8 April 2020

Exhibition comments - Horsley Drive Stage 2 – Building 1 (SSD 10404)

CLAY PRESHAW
Manager Catchment Protection

Figure 2 SSD10404 proposed works and the Upper Canal

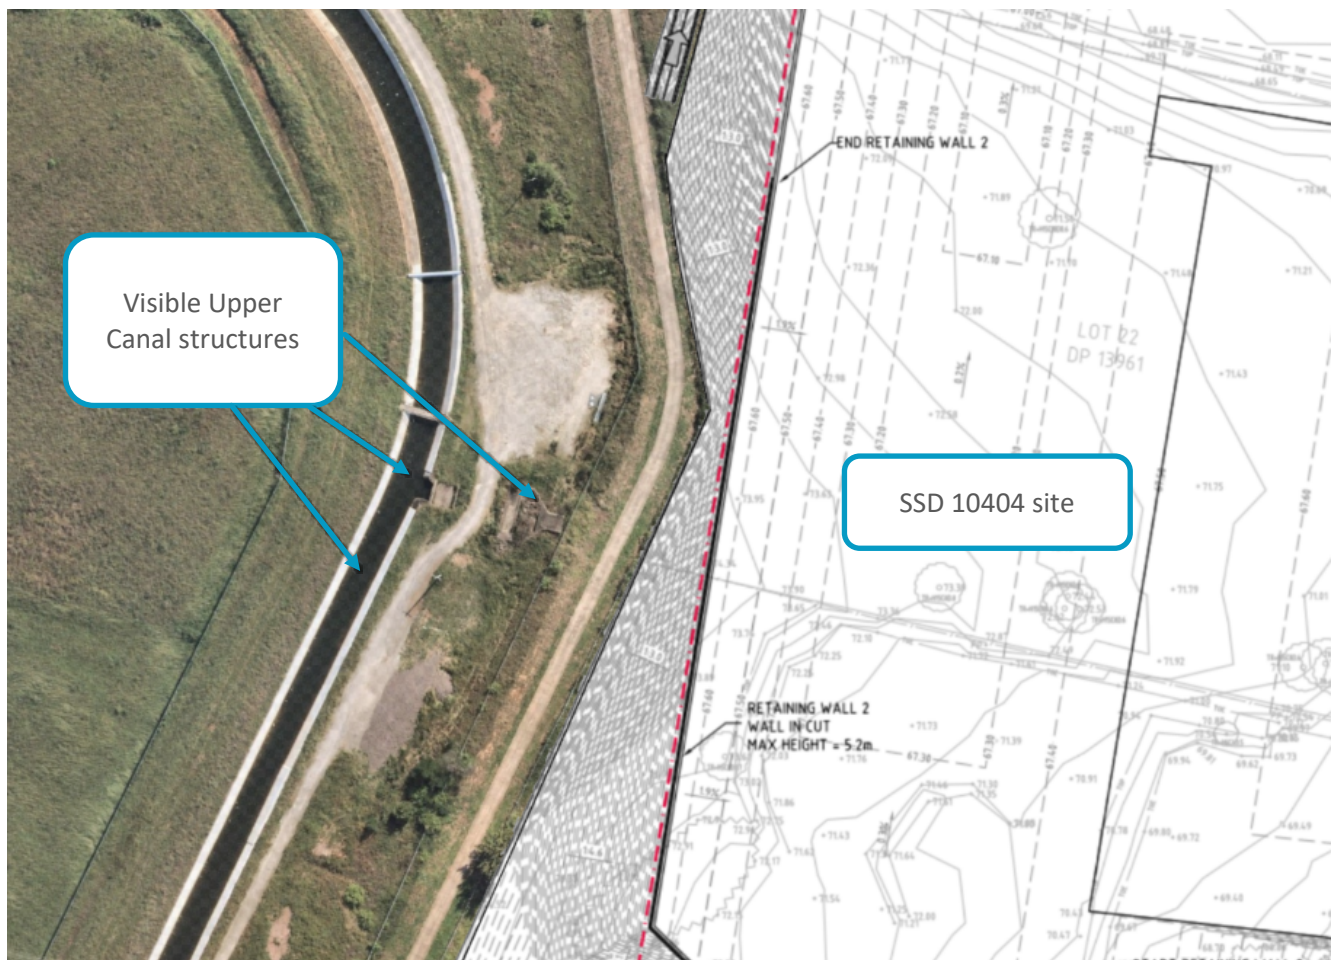
The EIS and Operational Noise and Vibration Impact Assessment (Appendix D – SLR, February 2020) have not addressed the indirect impacts of vibration on the Upper Canal during construction or list it as a sensitive receiver. In addition, the EIS does not specify any mitigation measures to address vibration impacts.

WaterNSW requests the development proposal confirms velocity limits and the impact the works will have on WaterNSW assets and specify any required mitigation measures.

DRAWING TITLE
EROSION AND SEDIMENT CONTROL PLAN
DRAWING No: C0114.92.18- DA20

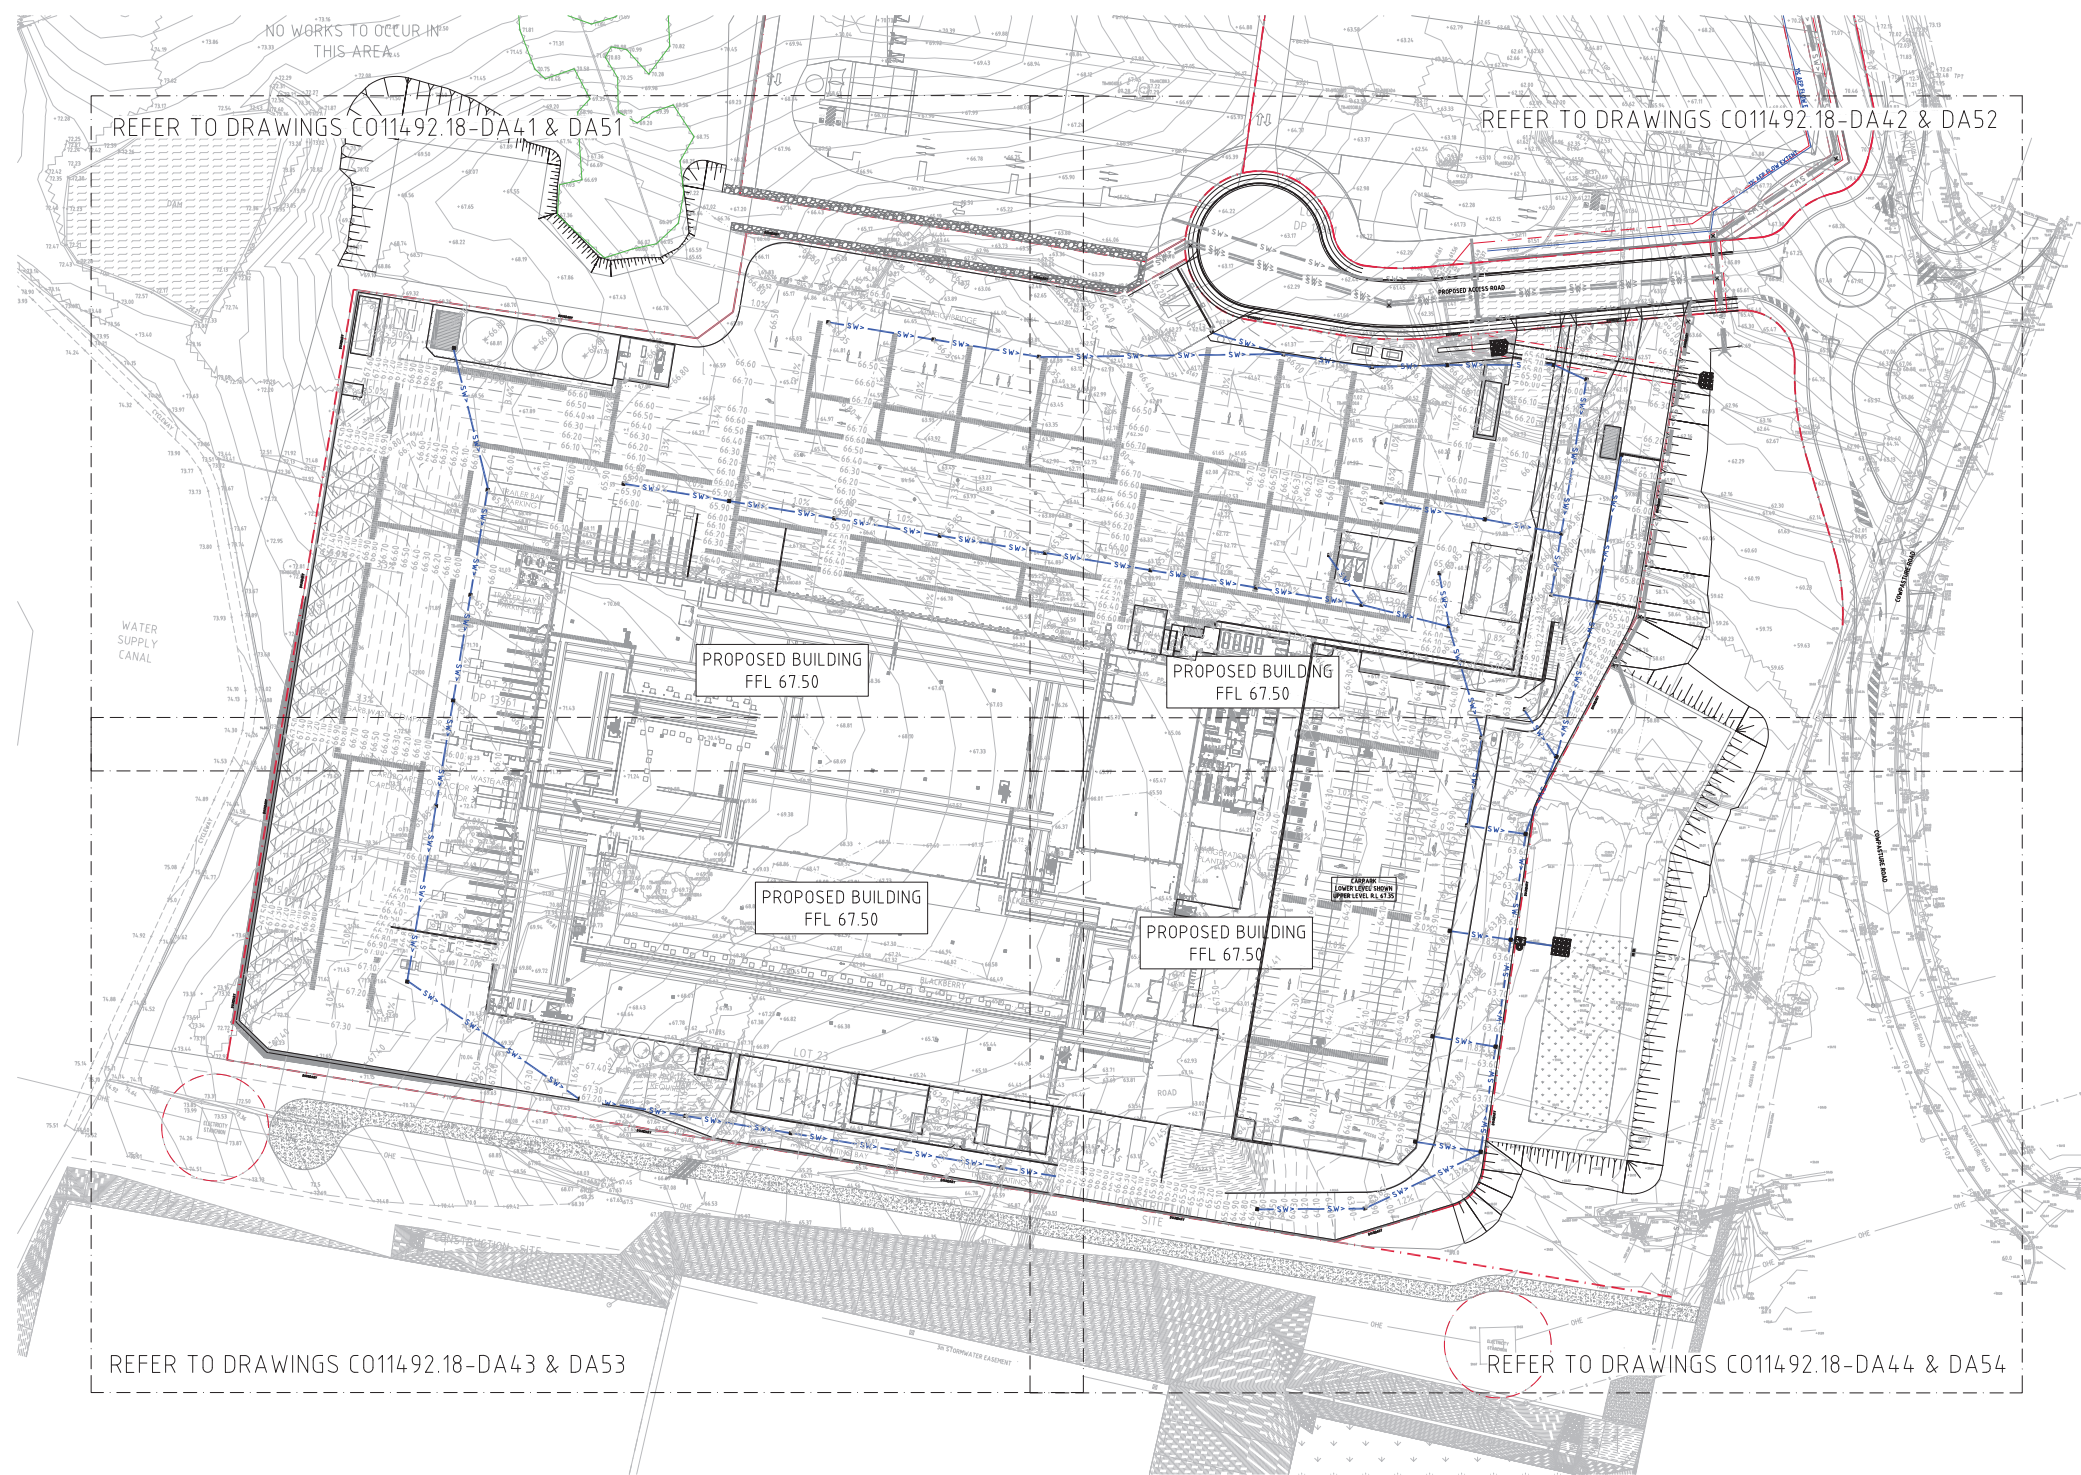
- *Effective erosion and sediment controls must be installed prior to any activity adjacent to the Upper Canal corridor to prevent sediment, dust or polluted water entering the corridor. The controls must be regularly maintained and retained until the building works have been completed and the ground surface stabilised or groundcover re-established.*
